PLANNING APPLICATION – 2020/91092

We have viewed the recently submitted Design and Access Statement for this Application and wish to submit our further objections to the development based on this report. Please also refer to our previous comments relating to this Application.

Drawing	Revision:
HD-A-697 -101	4

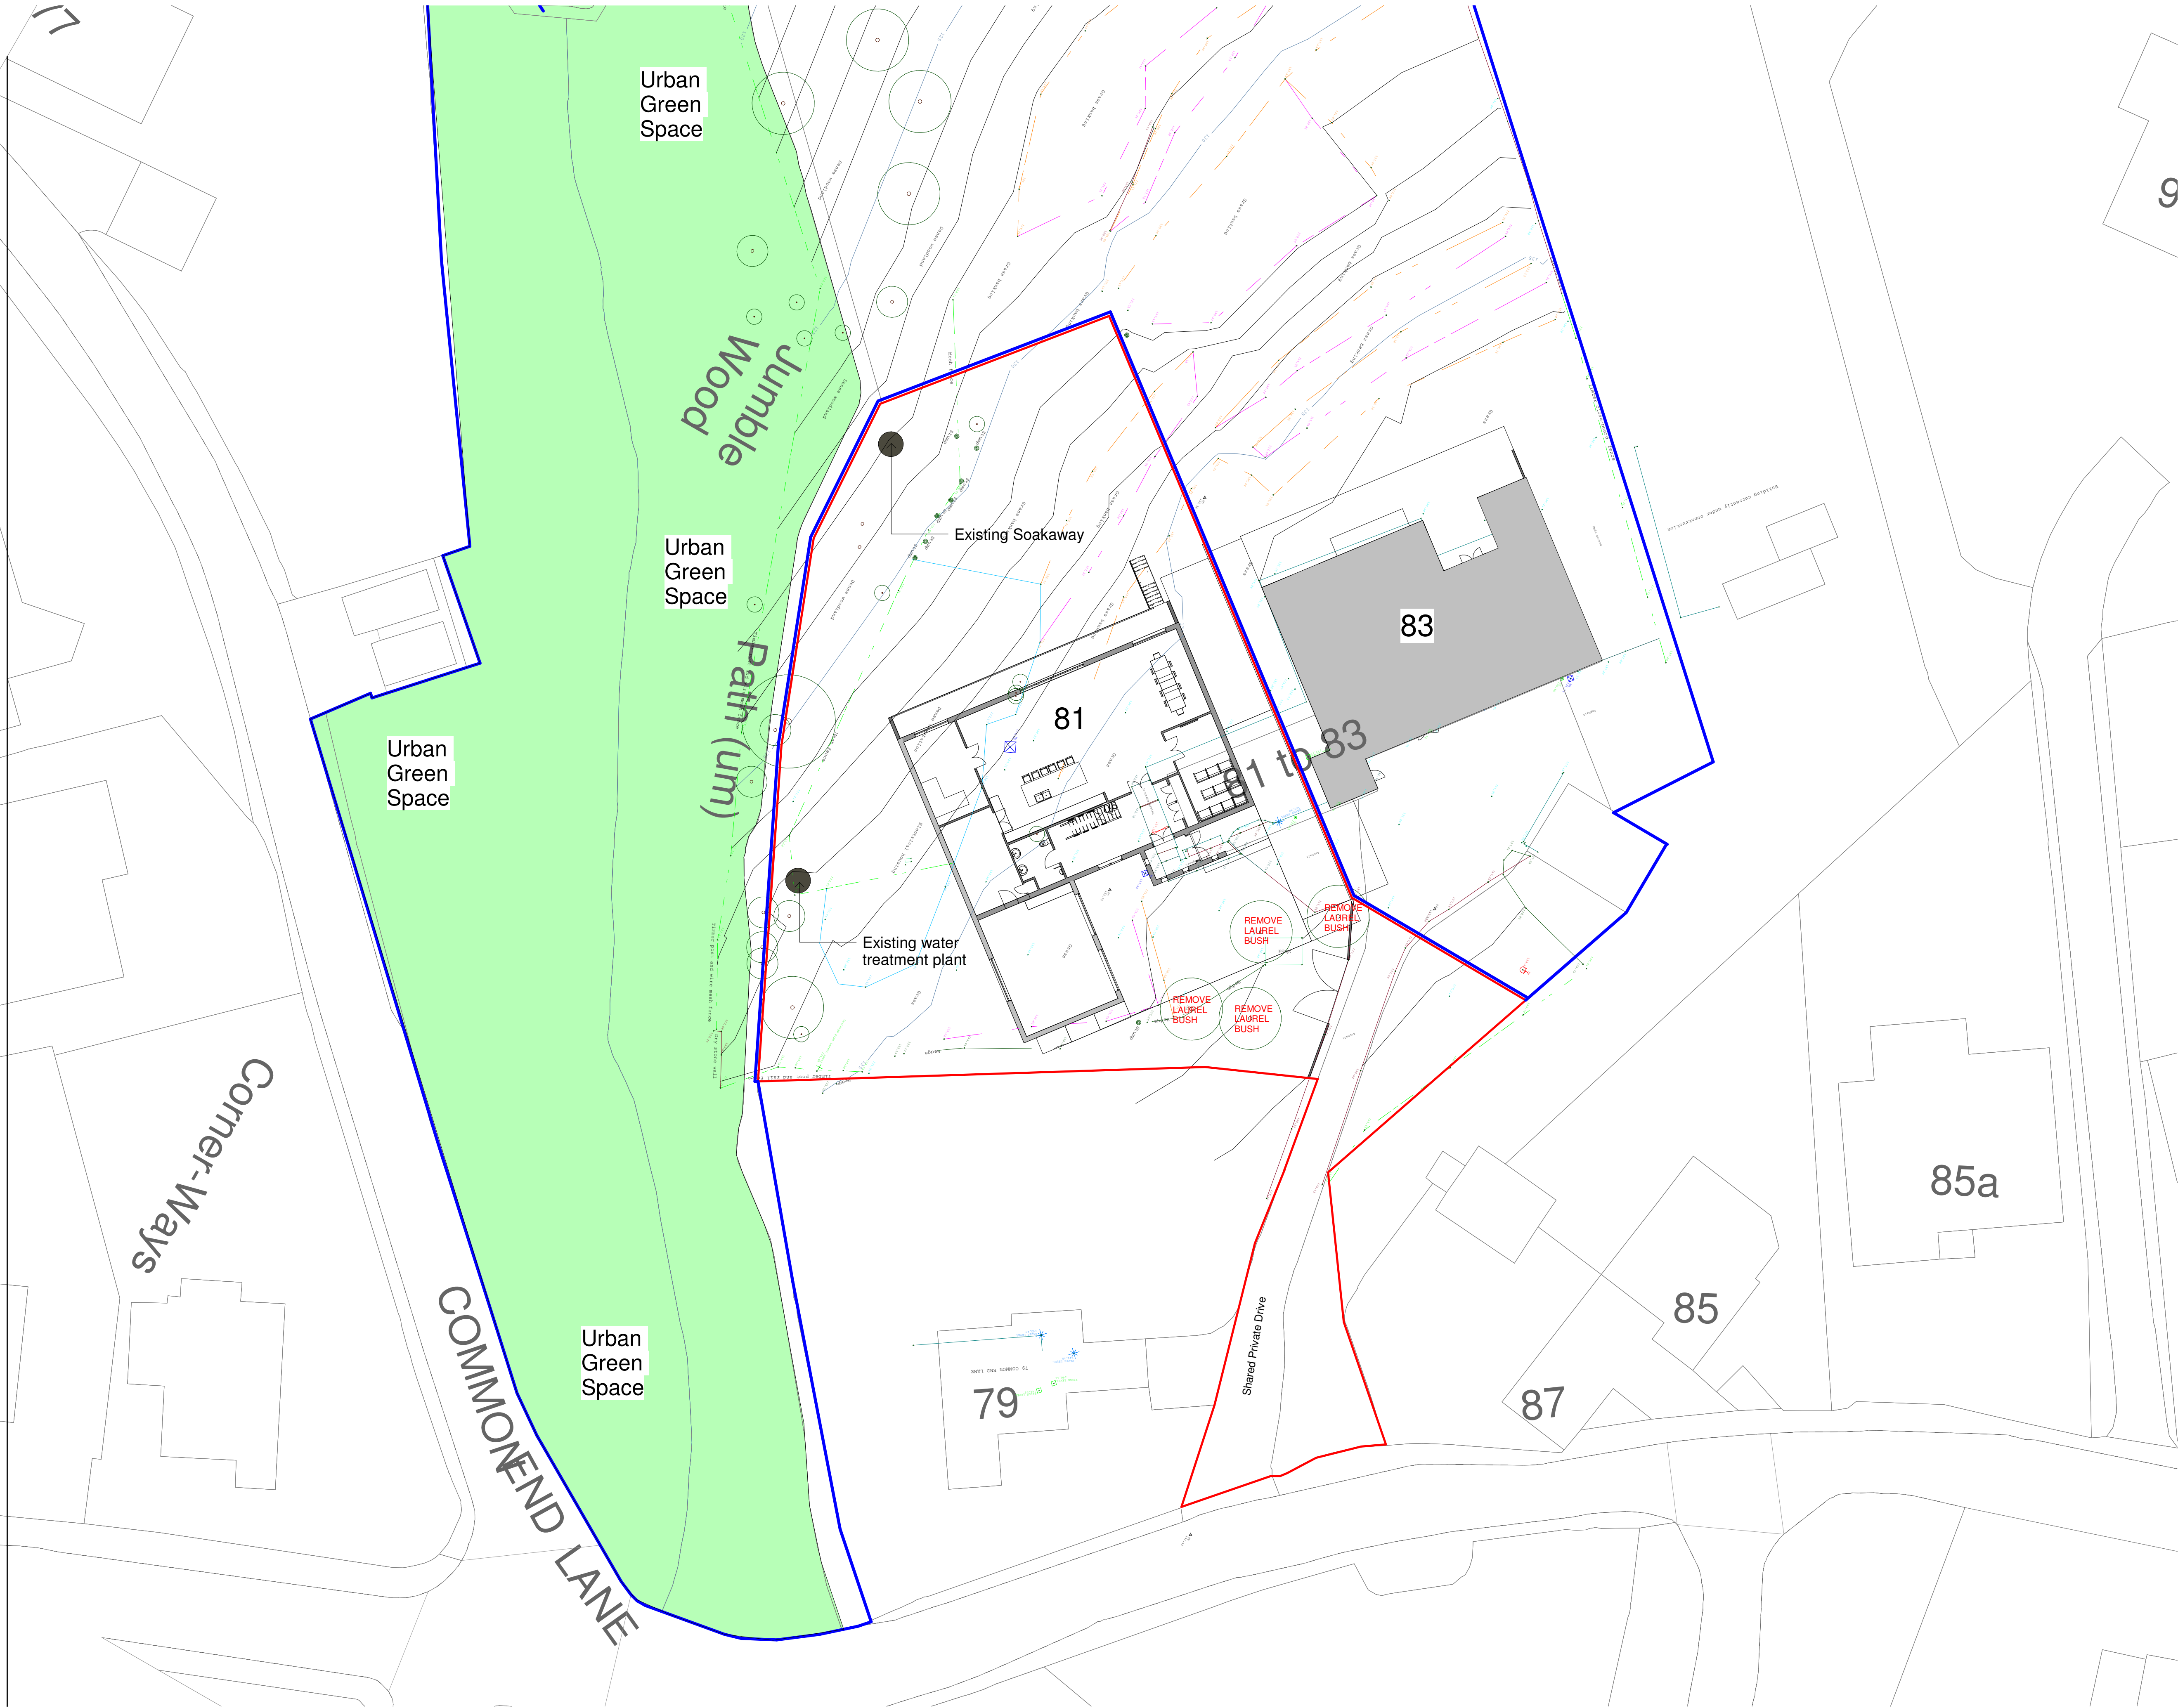
We also note that in Application 91092 that Drawing 101 recently listed and dated 26/6/20 shows a new red line to the boundary up to Common End Lane. Does this constitute a revised access layout? If this is not the case, why not?
